29 March, 2022

Your ref: MP06_0228_Mod 21

**RE: SHOALHAVEN STARCHES EXPANSION PROJECT - MODIFICATION 21
 REVISED PLANS**

DRAWN	DATE	JOB TITLE
P.C.	25/06/20	SHOALHAVEN STARCHES.BOMADERRY. NSW
CHKD	DATE	DWG TITLE
BH		MOD 21.PACKER ALTERATIONS.
APPD	DATE	SITE ELEVATIONS GA.
	SCALE	PROJECT No.
	1:2500	7323B
		DWG No.
		MN7323-000

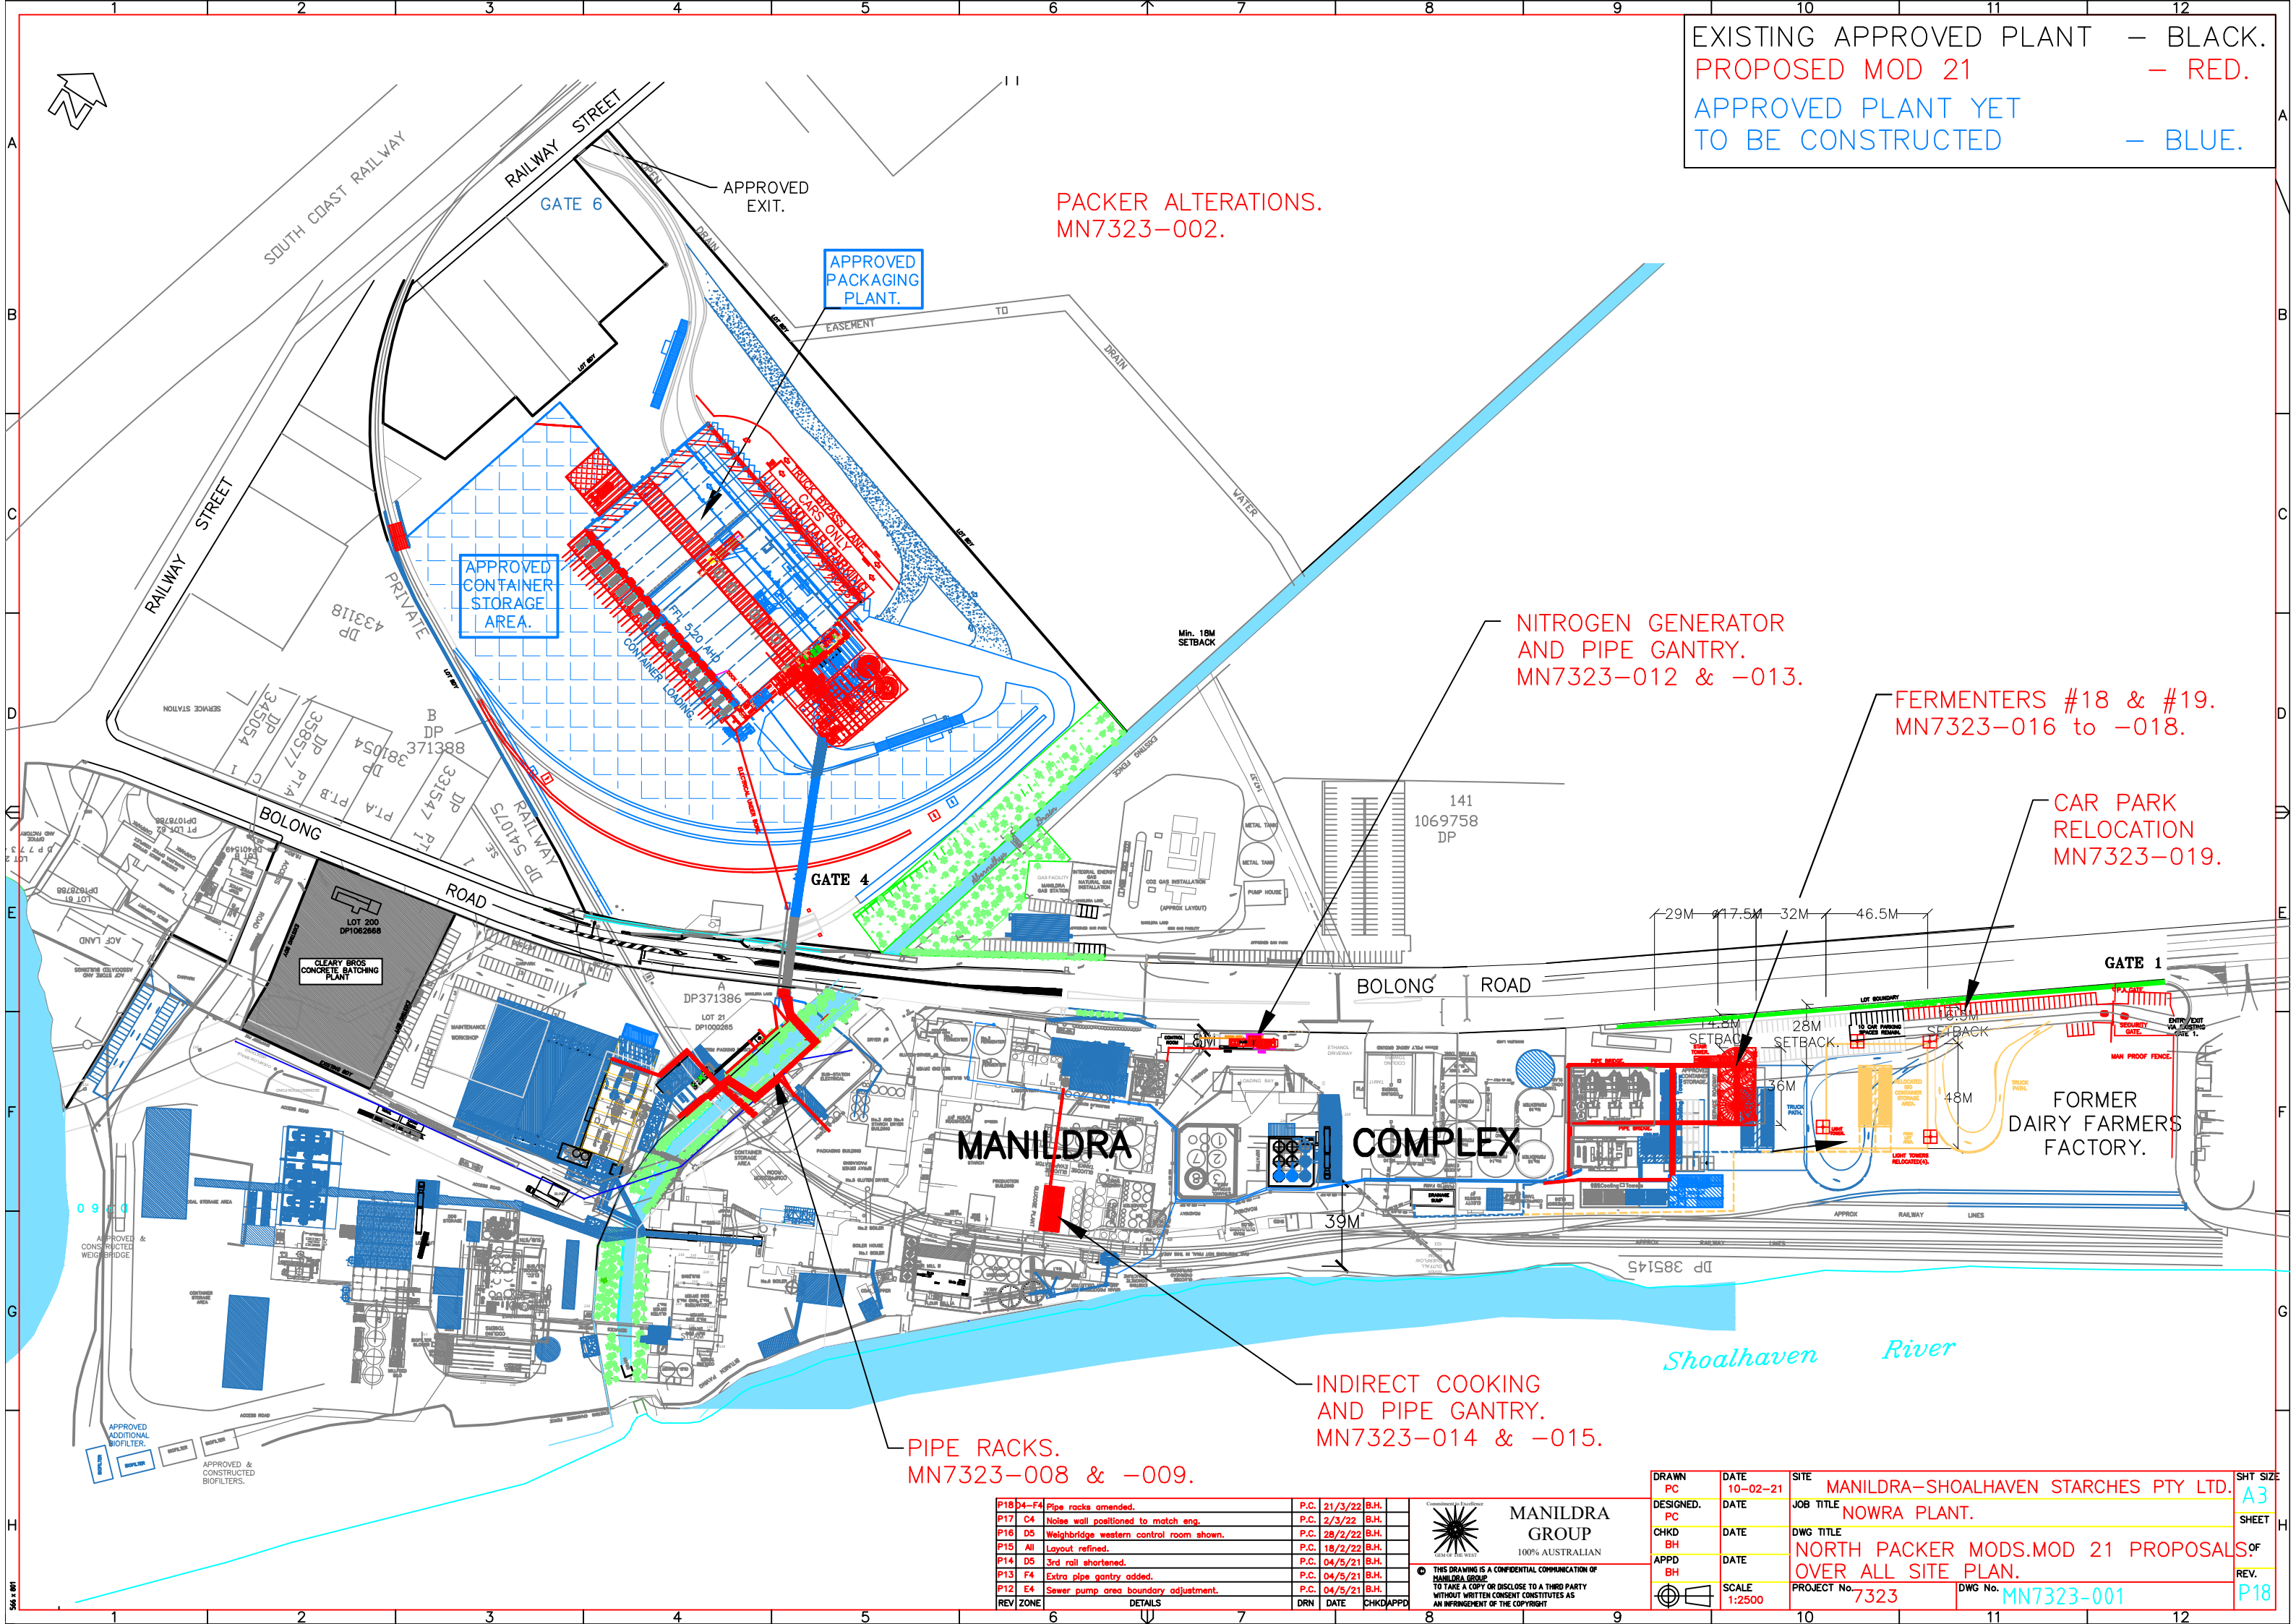
Drawing No.	Original Drawing Revision No.	Proposed Amended Drawing Revision No.	Description	Comments (Cloud Markups)	Rationale
7323-000	P20	P21	Site elevations	Pipe gantry removed.	
7323-002	P16	P23	North Packing site plan	<ul style="list-style-type: none"> Hygiene station shown and battery room relocated. Pipe bridge removed. Compressor and Plant room relocated. Maintenance Building and container cleaning moved off noise wall. 	
7323-003	P12	P19	Packaging/Warehouse building	<ul style="list-style-type: none"> The noise wall has been extended to within footprint of packing plant. Hygiene station shown and battery room relocated. Office relocated to eastern side of building Plant and compressor room relocated. Truck awning enclosed. 	If packing plant building is constructed in stages, the noise wall will need to reflect this construction staging.
7323-004.pdf	P10	P13	Reconfigured carpark	Relocated and enlarged office / amenities area. The original plans provided an office area with dimensions of 3.1 m by 18.1 m (area 56 m ²). The amended proposal will have an office and amenity area over two levels, with an overall floor area of 504 m ² .	Needed to be relocated and enlarged to provide a more workable format and enable sufficient space for facilities.

P.C.	DATE	SHOALHAVEN STARCHES.		SHT SIZE
CHKD GM	25/08/20	DWG TITLE		A3
APPD	DATE	NORTH PACKER MOD 21. PRODUCT SILOS.		REV.
	SCALE 1:500	PROJECT No. 7323-005	DWG No. MN7323-005	P16

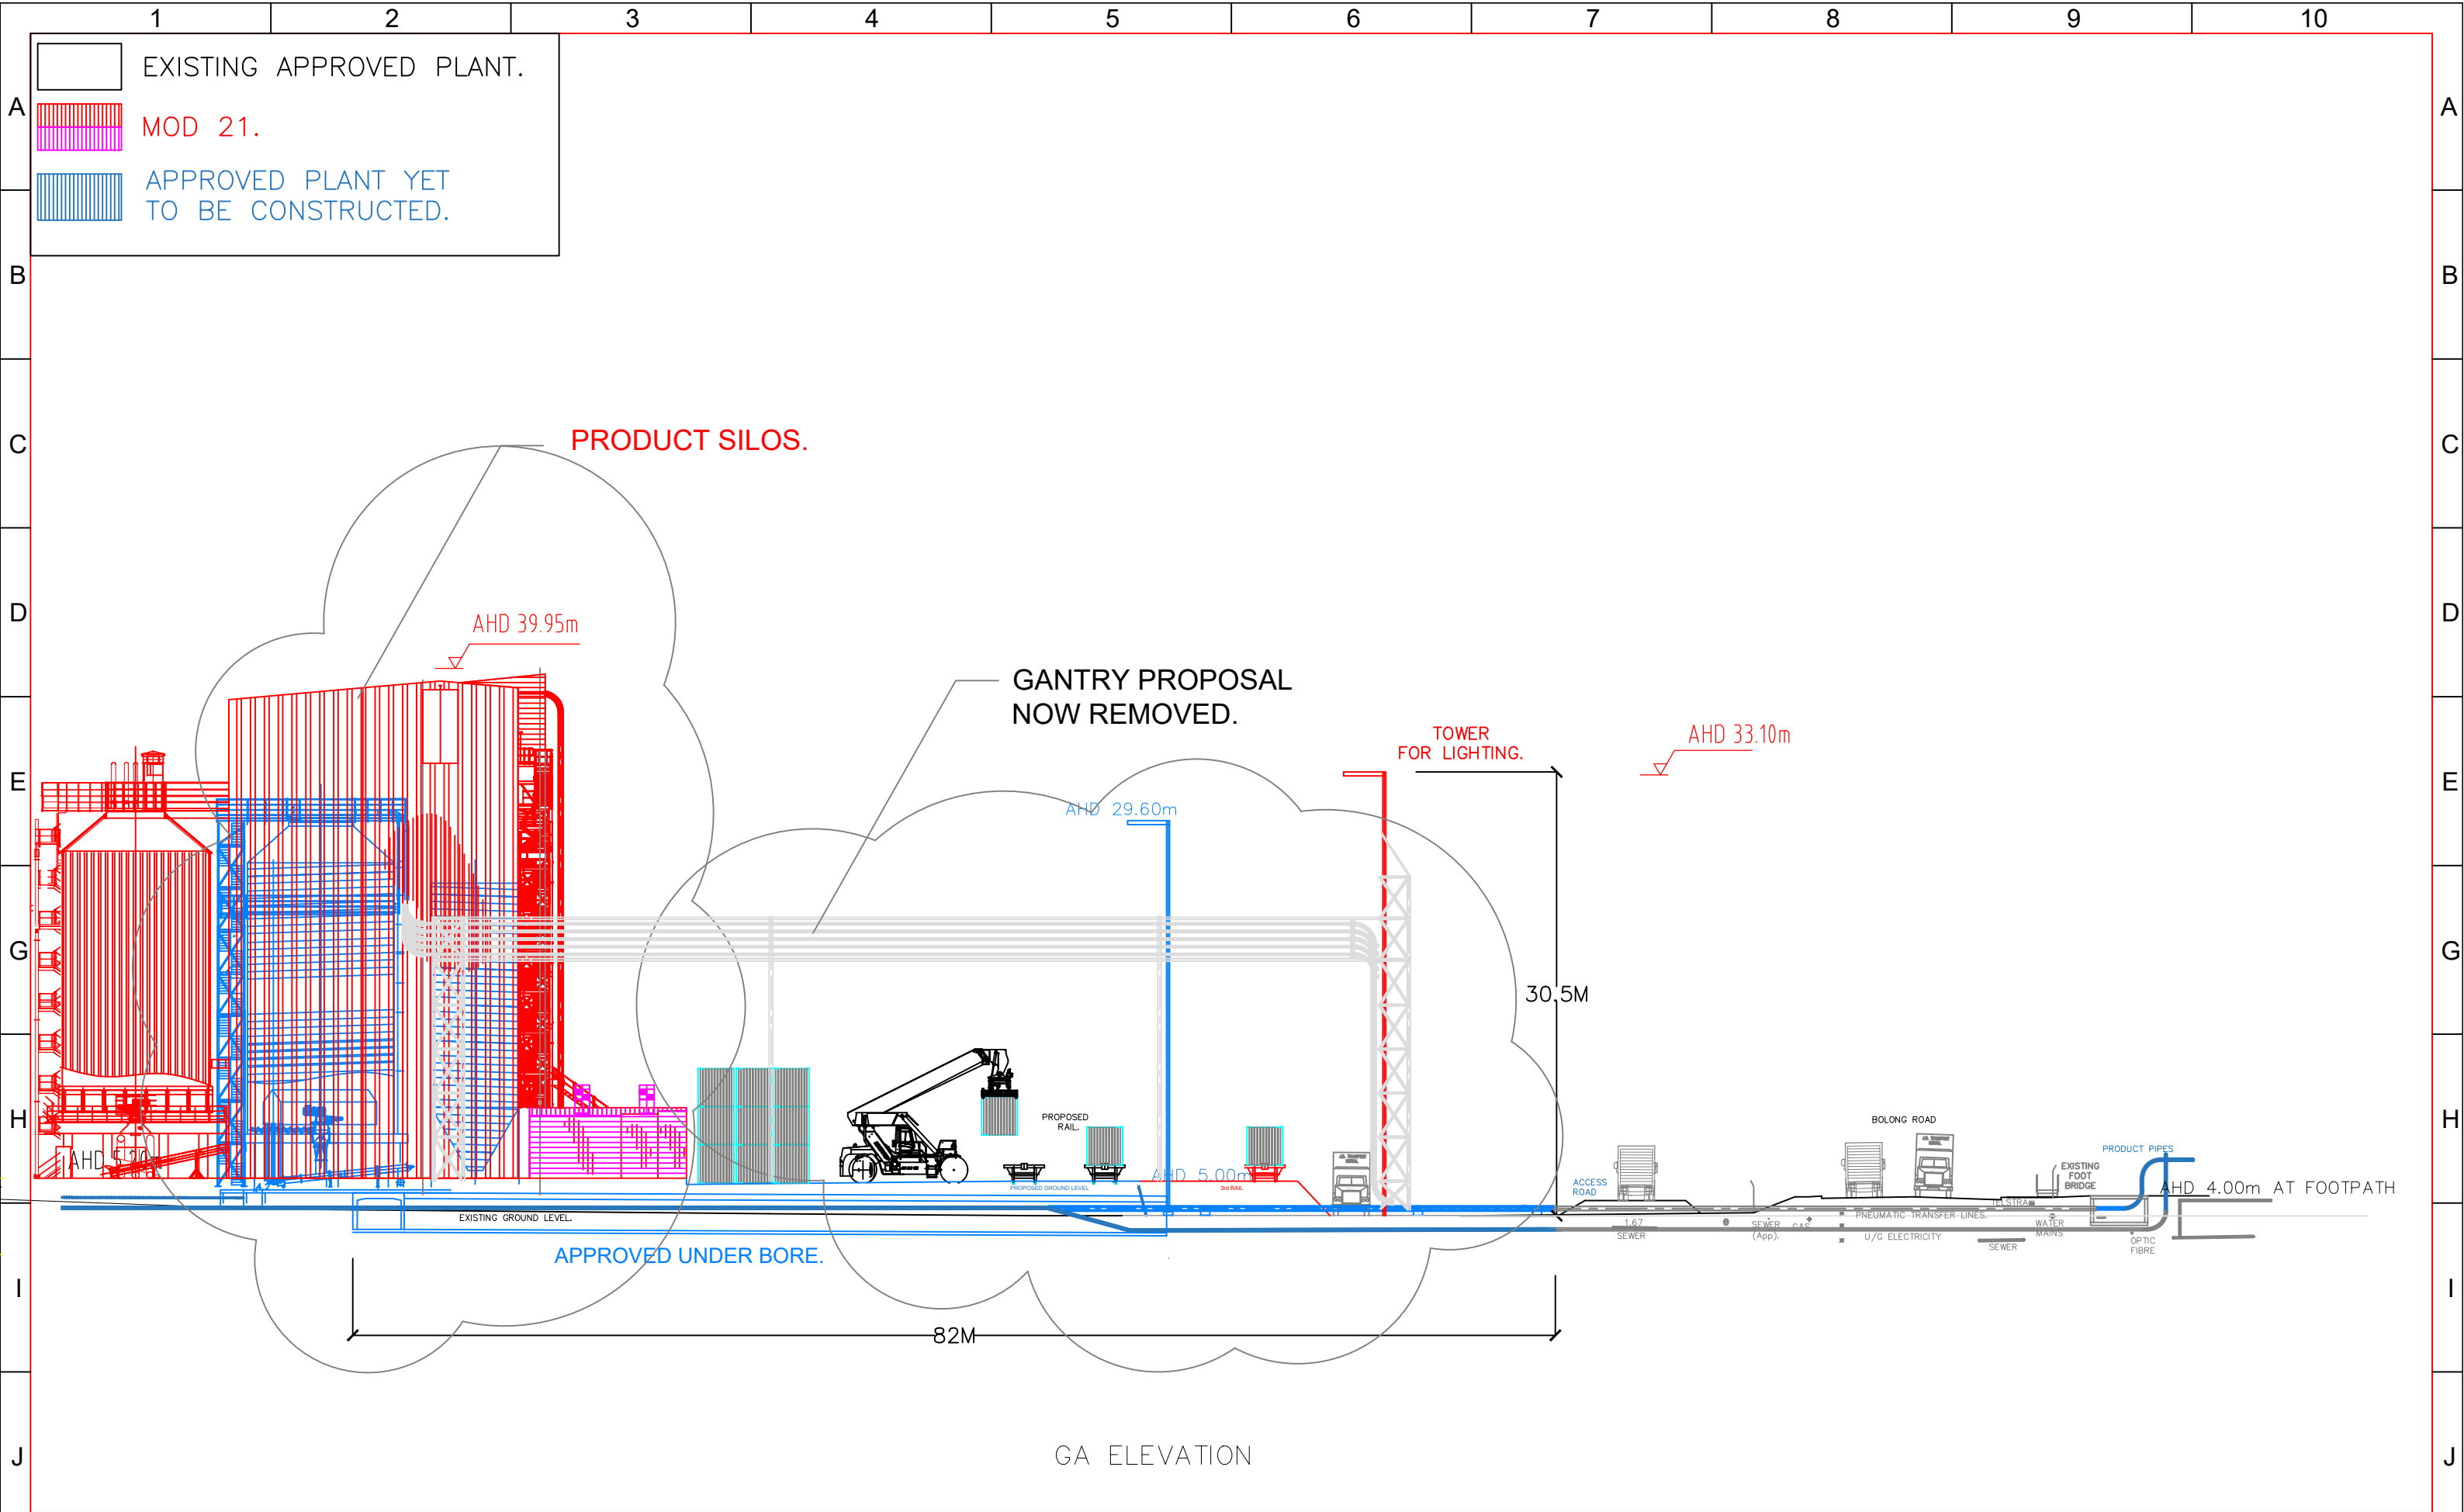
Drawing No.	Original Drawing Revision No.	Proposed Amended Drawing Revision No.	Description	Comments	Rationale
7323-005	P10	P16	Product silos	Truck awning enclosed. Plant and compressor room in silo area relocated to south side of building envelope.	To comply with recommendations of noise assessment. Operational workflow requirements have resulted in larger structures and relocated to more appropriate positions.
7323-006	P10	P11	Pneumatic transfer lines Gantry	Remove pipe bridge.	Lines will now be placed underground as originally approved.
7323-007	P07			Removed.	Retracted drawing.
7323-008	P09	P10	Pipe Gantries (South side)	Pipe gantry bridge is to be a foot bridge. Elevation was incorrect.	To ensure satisfactory clearance from HV overhead power lines and relocated to avoid some of the trees.
7323-009	P10	P11	Pipe Gantries Site plan (South side)	Pipe gantry bridge is to be a foot bridge. Elevation was incorrect.	Clearance provided to HV overhead power lines and relocated to avoid trees.
